Our Case Number: ABP-319866-24

Re: Proposed development known as North Irish Sea Array ("NISA") Offshore Wind Farm
Located off the coast of Counties Dublin, Meath and Louth (www.northirishsearraysid.ie)

Re: North Irish Sea Array Offshore Windfarm OA29N.319866

I am making an observation opposing the specific location of the NISA wind farm. I believe it would adversely impact the visual amenity of Skerries where I live. Instead of the current proposal, I would propose to move this 5km further out which would bring the visual impact down to a more moderate level. I enclose a cheque for 50 euros. I ask for an oral hearing.

VP24 (View 1) Baseline Photo and Wireline  
Amenity Area Skerries (Fingal),  
Co. Dublin

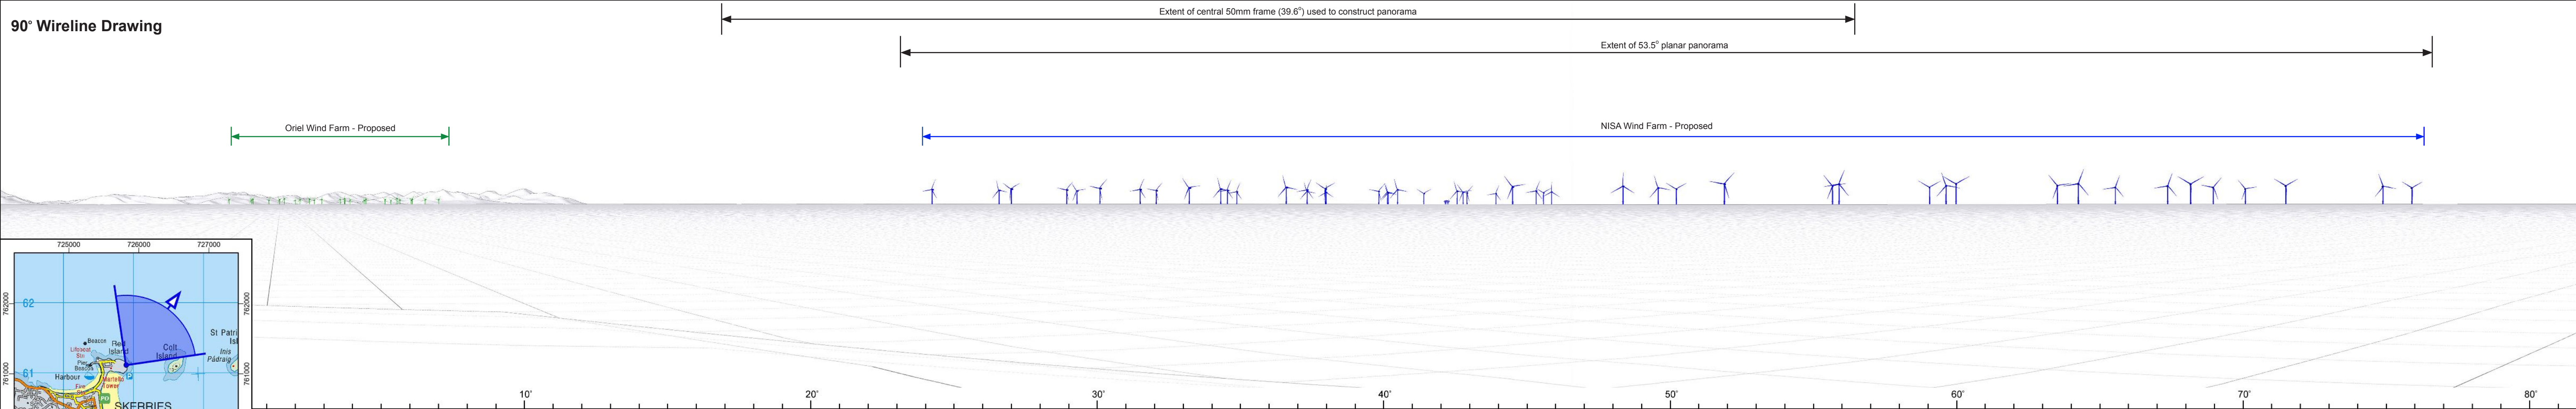
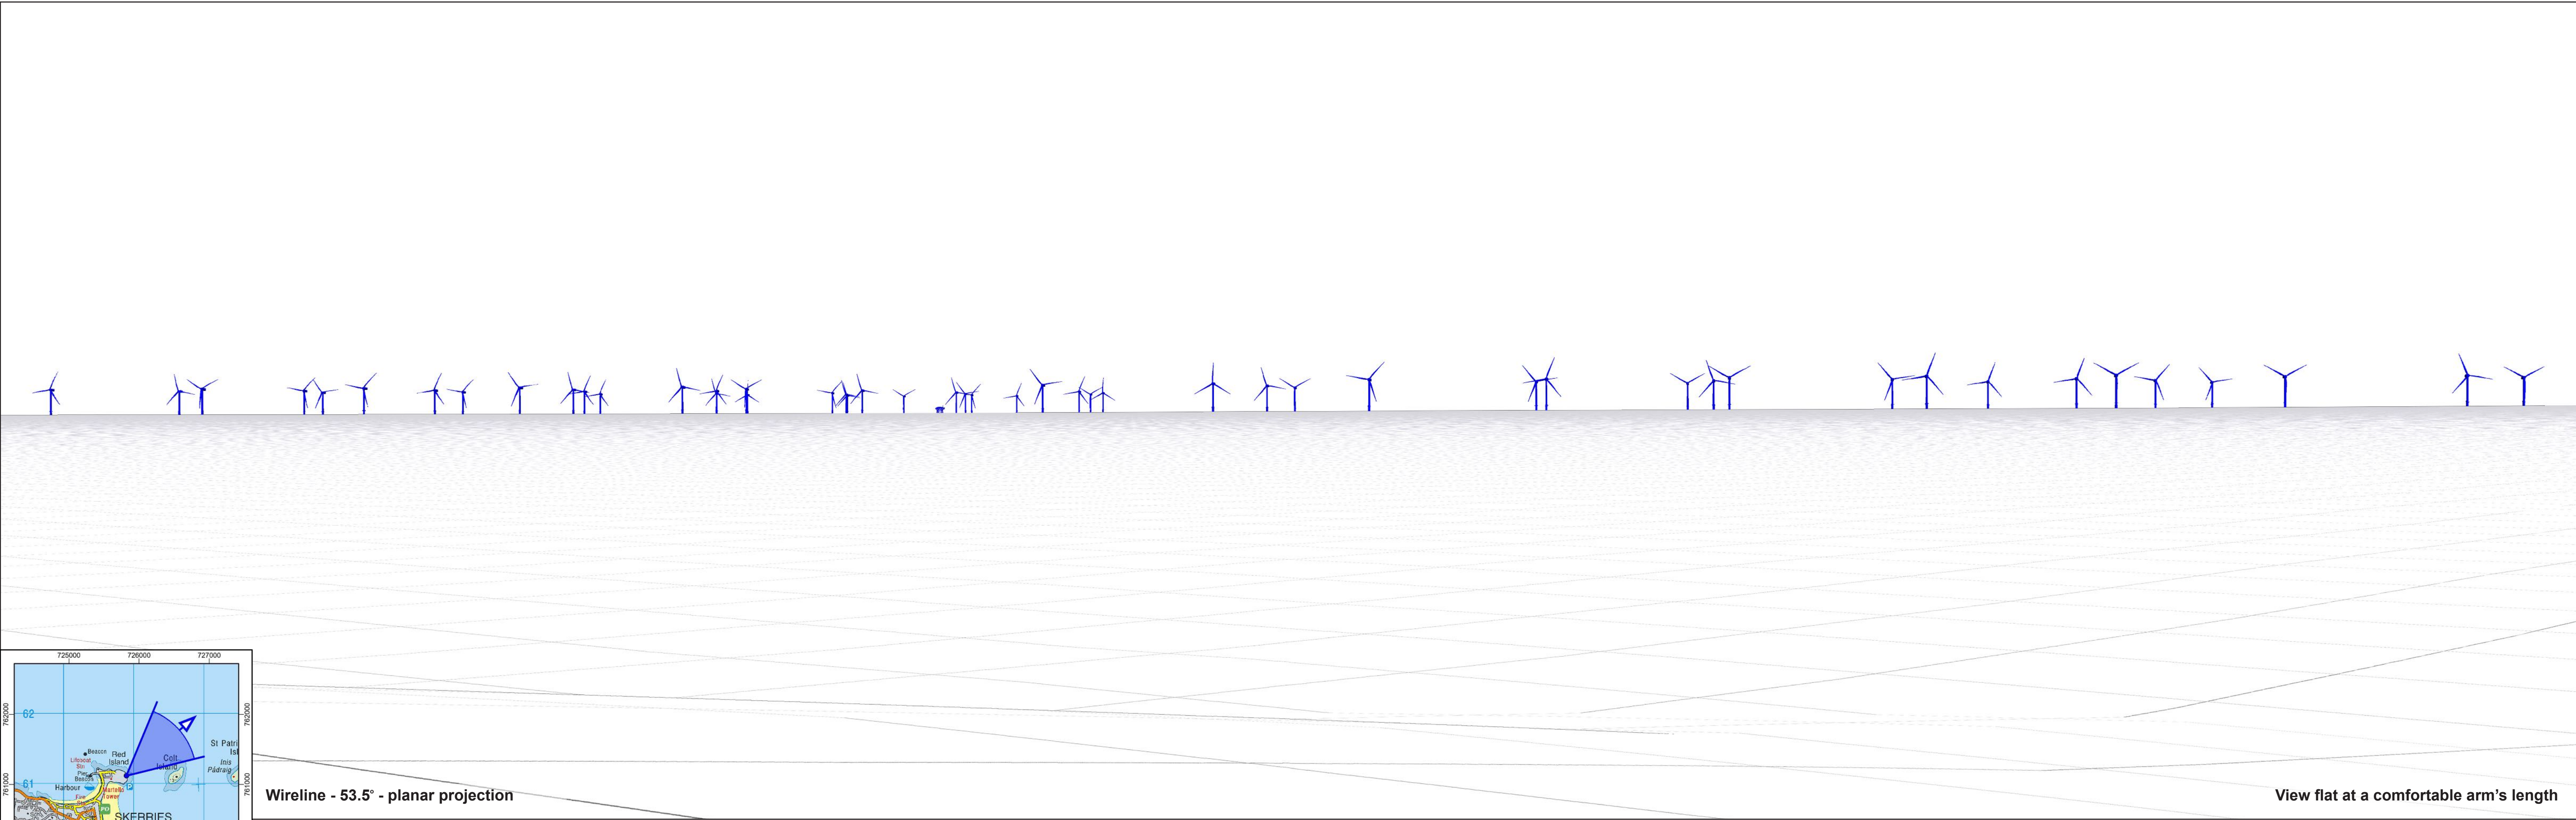
The photomontage for Skerries looks better with the smaller turbines. The smaller turbines $aH:D$ is approximately 2.1 which is just about the limit before the turbines look imposing. The larger turbines $aH:D$ of 2:4 would look very dominant and probably look out of place.

The visual impact is heightened at Skerries which is a headland and is therefore the closest point to the wind farm at 12.9 km. In comparison, Balbriggan at 15.9 km is 3km further away because of its location in the large bay between the Skerries and Clogherhead headlands.

Skerries is a unique scenic coastal town on the east coast and a very pleasant location for day trips for the general Dublin population. The proposed wind farm is off to one side and scenic views without turbines would still be possible by looking backwards from the headland over the south strand and north harbour. However, the turbines are within the view, although not in line of the Mourne mountains and so would be notable and impact the character of the area. The $aH:D$ of approximately 2.1 would be improved if reduced to 1.5. Also, the angle of 52 degrees is within peripheral vision and acceptable. This could be improved if reduced slightly.

My alternative NISA wind farm is shown in Figure 2 for 2 options for 35 and 49 turbines. This moves out the wind farm by a further 5km from Balbriggan shown by the marked dimension. The shape is kept the same as the current proposal.
